DEPARTMENT OF PLANNING REQUEST FOR ADDITIONAL INFORMATION

Subject: Proposed Darlington Point / Coleambally Ethanol Plant and Intensive Dairy, "Tubbo" Station – Murrumbidgee Local Government Area

Concerns with the Proposed Four Arrows Ethanol Plant & Intensive Dairy at Coleambally

Major Project Application
No. 06-0020.

Figure 20 – Predicted 99th percentile compliance odour levels at far field receptors due to emissions from the intensive dairy

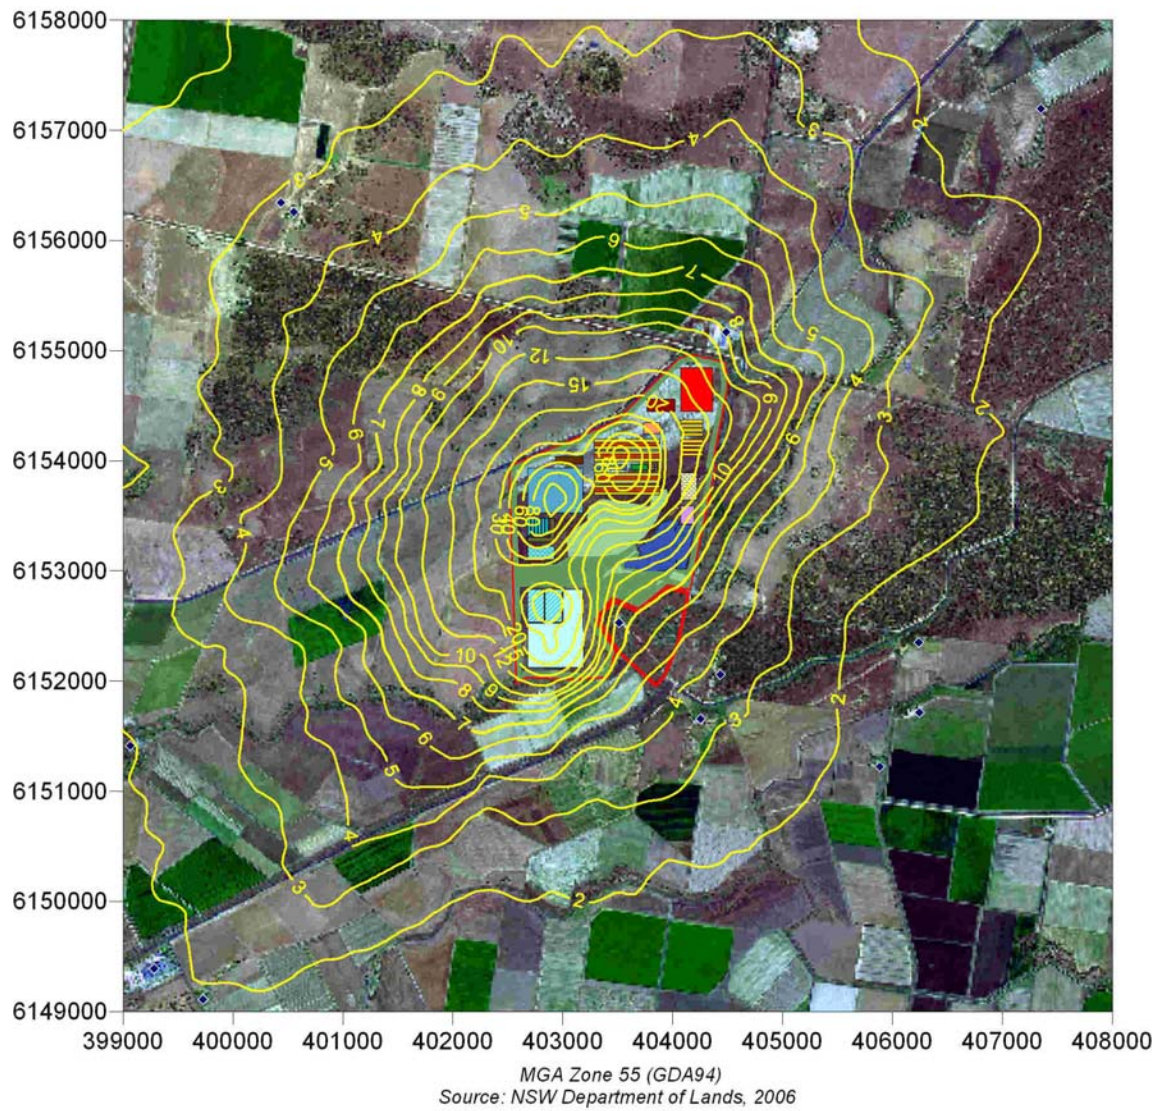
The analysis in Figure 20 of the Holmes Air Services report shows that compliance odour levels predicted 99th percentiles emission levels from the dairy will reach well beyond Farm 538 and the emissions from all sources figure 22 will also reach well beyond Farm 538.
